DEVELOPMENT REVIEW BOARD  
SUPPLEMENTAL SUBMITTAL

PROJECT NO. PR-2019-002277  
Application No. SI-2019-00246

SUBMITTAL DESCRIPTION: DRB Site Plan Resubmittal.

RE: Adagio Apartments  
PR-2019-002277

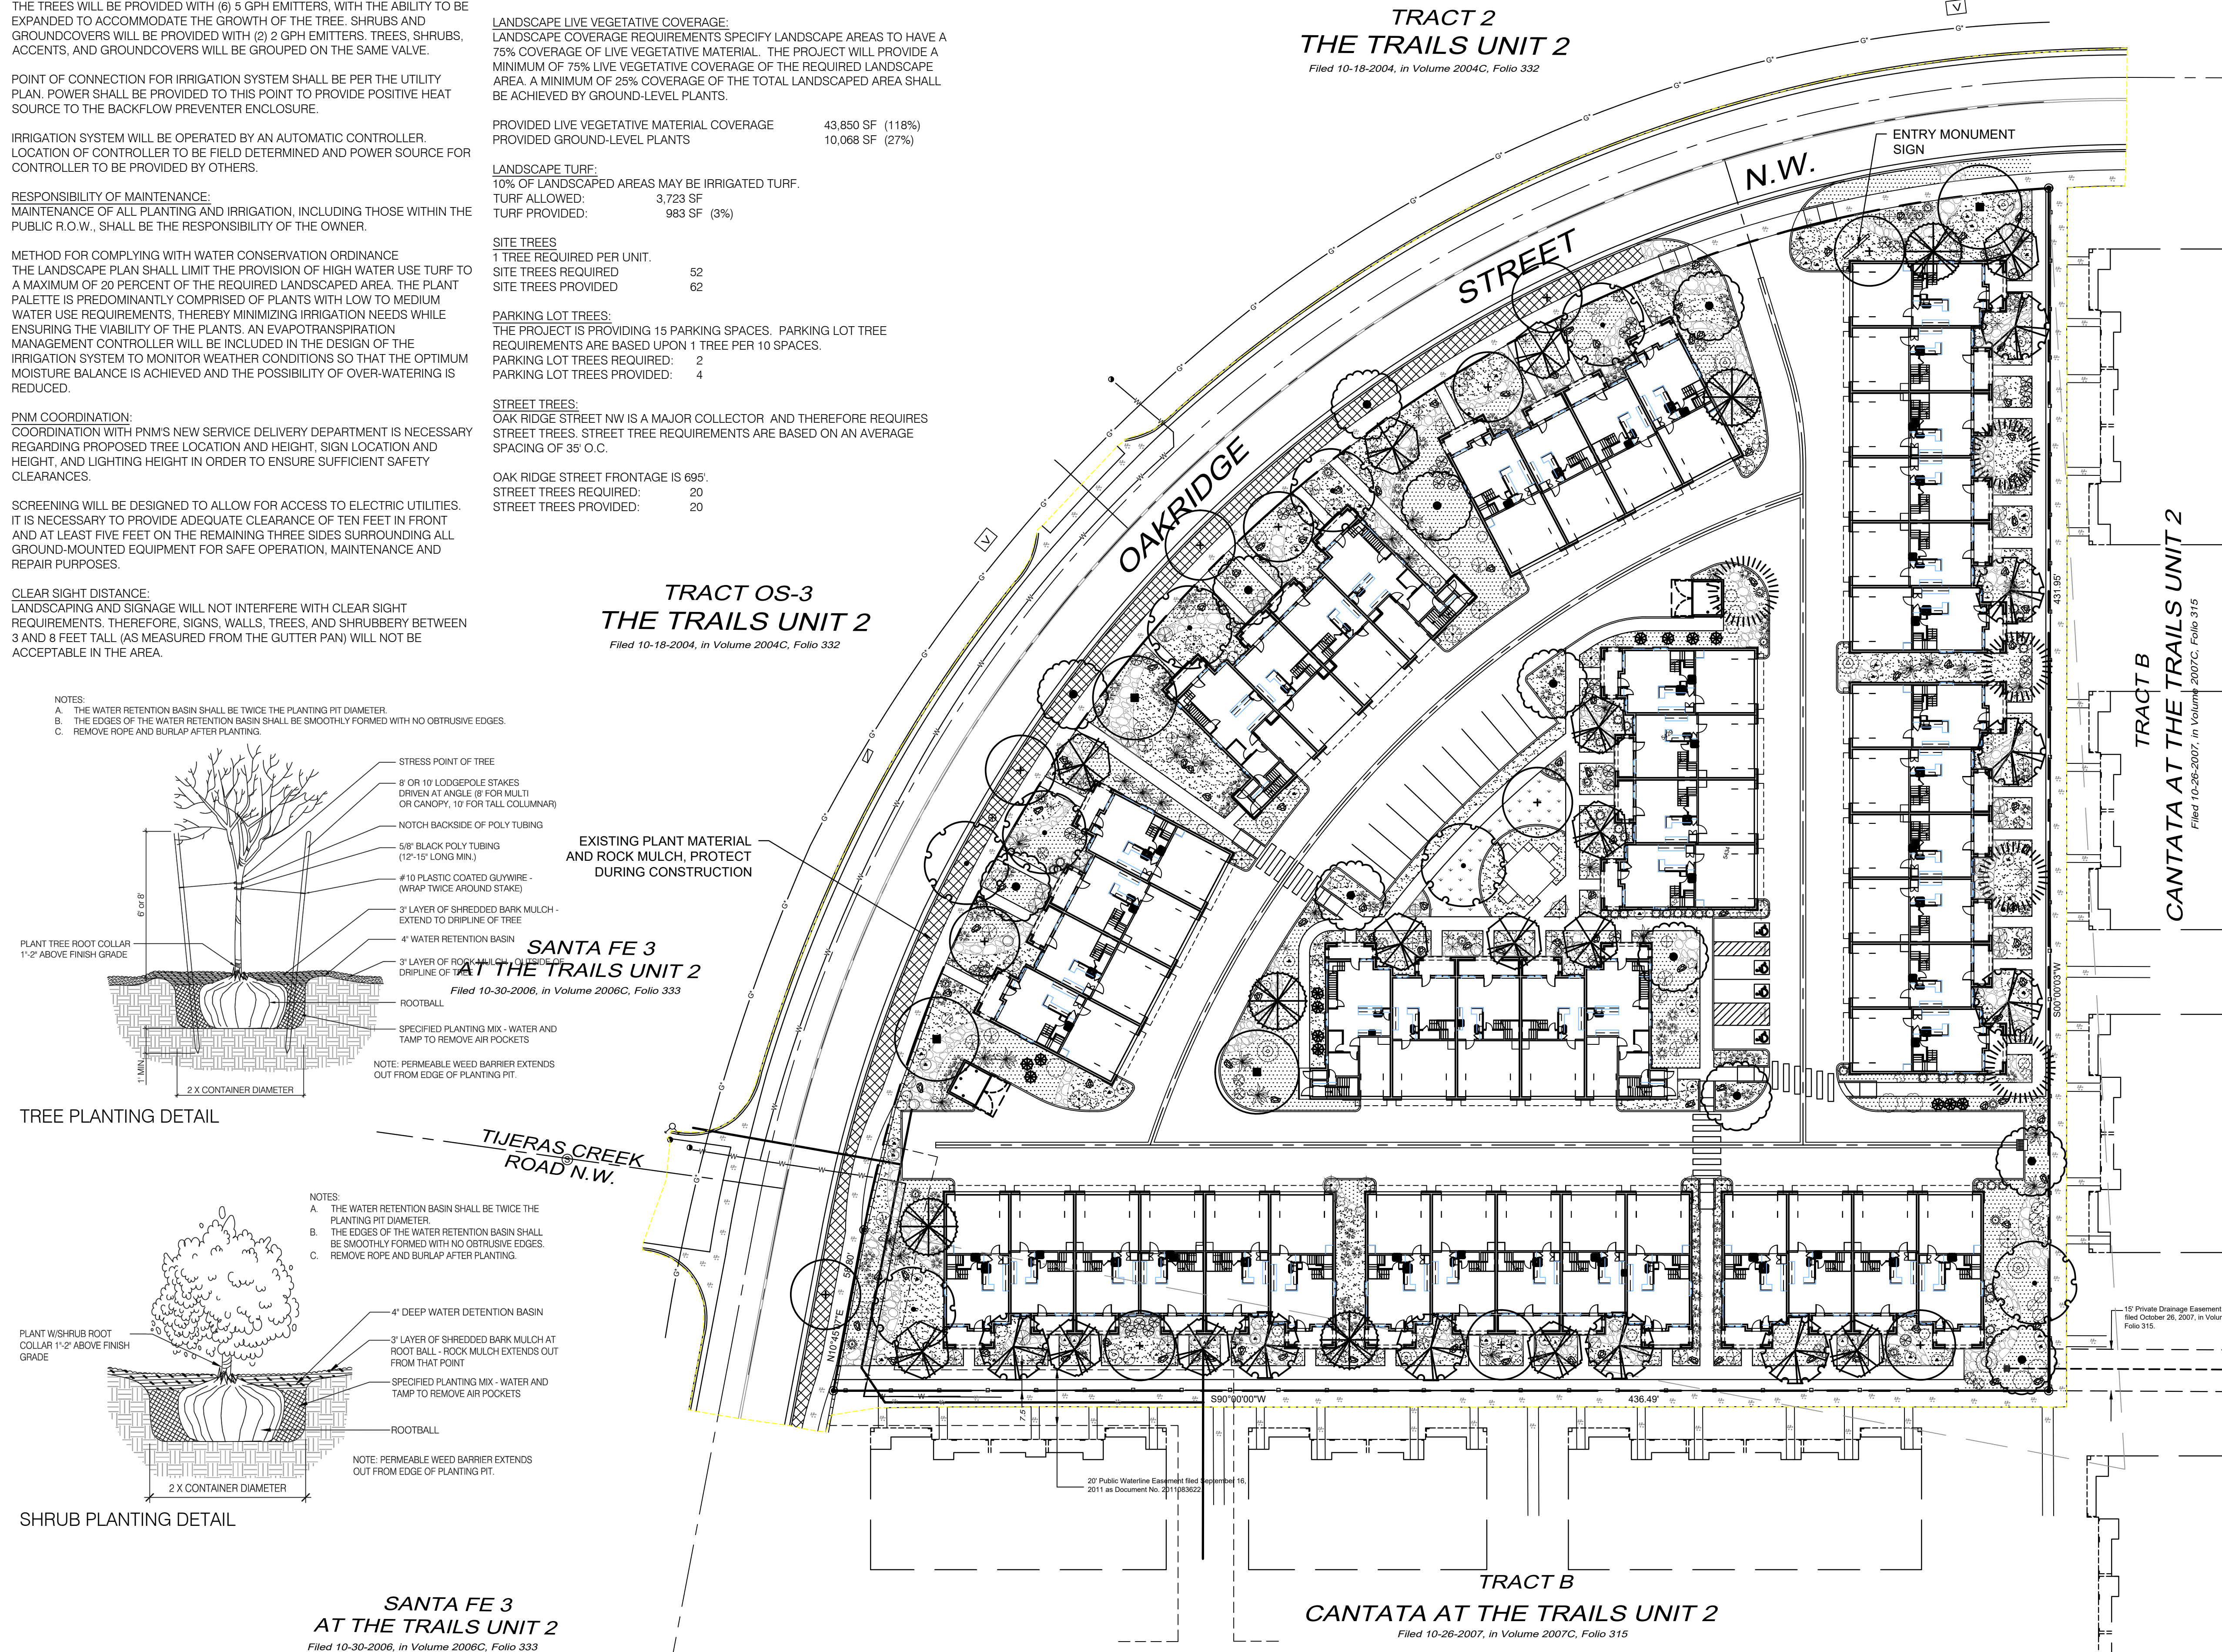
- / Provide sight distance lines on the landscaping plan that match the site plan.
  - o *Response: The revised landscaping plan attached has been updated to show the sight distance lines that match the site plan.*
